Subject: 22/01559/F The Maltings, Tower Road, Burnham Overy Staithe.

I have prepared a formal re-submission based on the conversations I've had with both Darren and Steven. Please see the attached.

Dwg: 1.11
Rev: 03

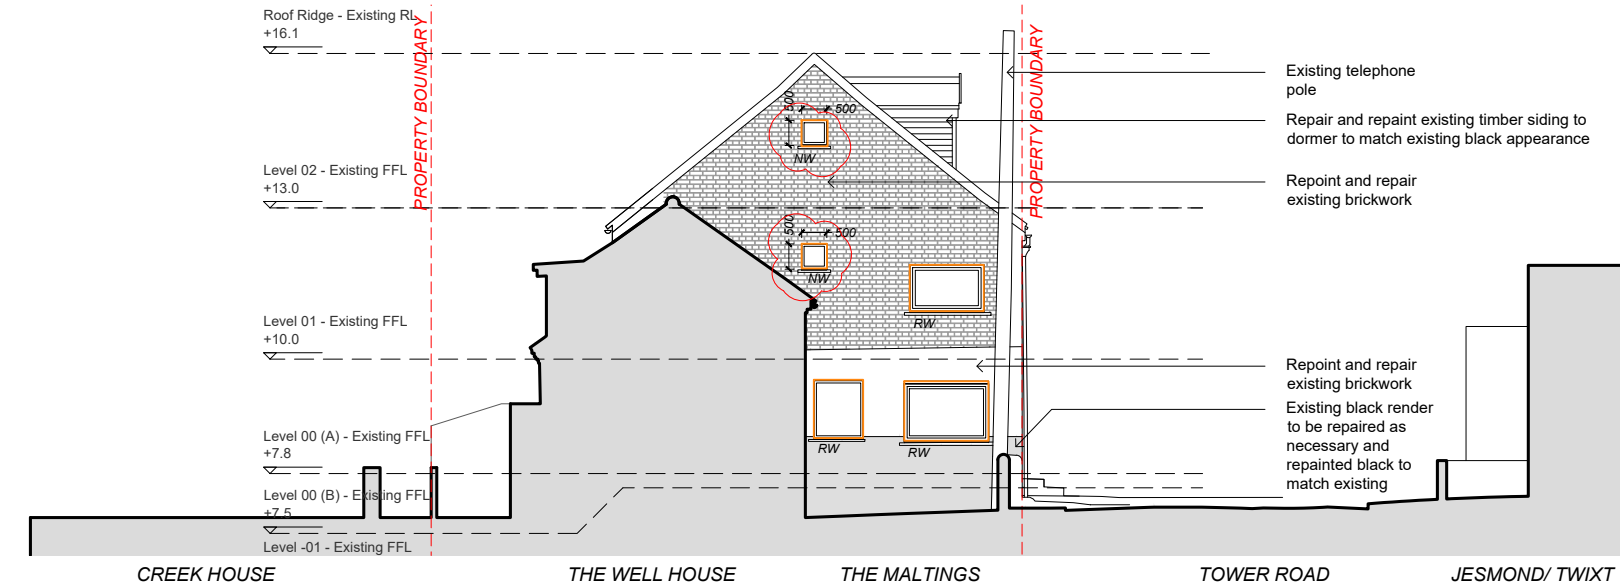
Steven: The high level windows on the North Facade have been re-sized and re-arranged. The two new windows on the West Facade have also been resized and aligned. There have also been some adjustments to the arrangement and quantity of conservation roof lights. As the parking will remain largely as is, the garden wall will also remain largely as is however with the opening increased to accommodate a larger vehicle.
